Application Reference: 6/2022/1730/COND

Proposed development at: Beadles Volkswagen Van Centre Harpsfield Broadway
Hatfield AL10 9TF

Proposal: Submission of details pursuant of condition 8 (piling) on planning
permission 6/2020/3222/MAJ

BY:	Author	DRAWING TITLE:	PILE SETTING OUT GA
CHKD:	Checker	SCALE @ A0:	As indicated
DATE:	Jul22	DRAWING STATUS:	CONSTRUCTION
Rev:	C1

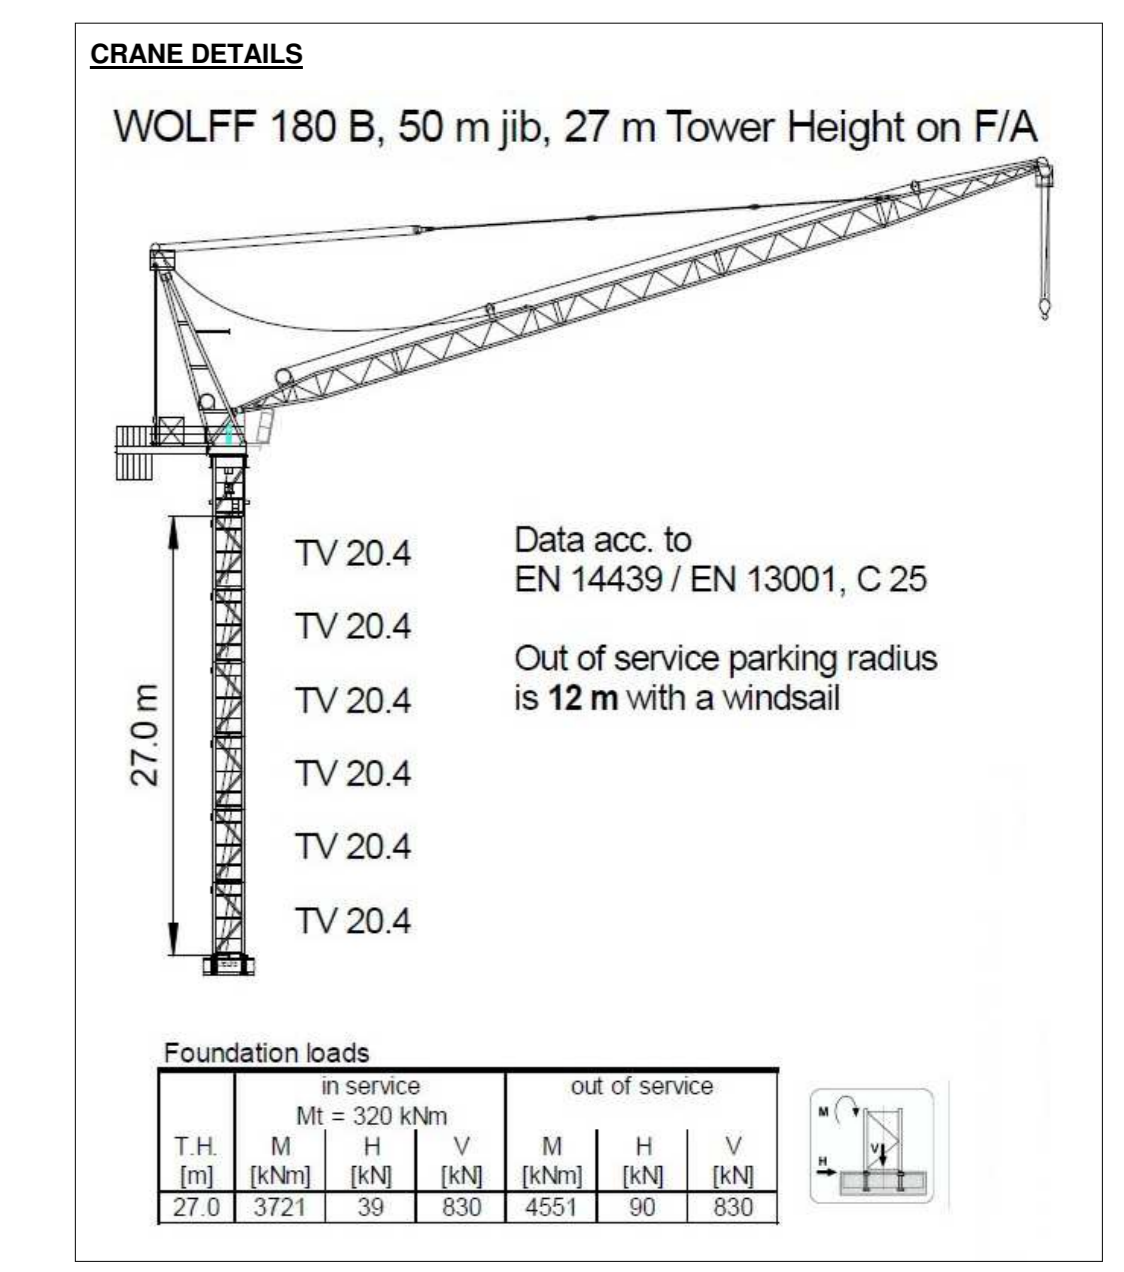
The submitted information does not confirm that the piling works will not exacerbate
the bromate and bromide groundwater pollution beneath the site. Consequently, this
condition cannot be discharged.

The applicant will need to submit further information showing that risks of exacerbating the existing groundwater pollution through the piling method have been identified and addressed. The following documents should be helpful in this case:
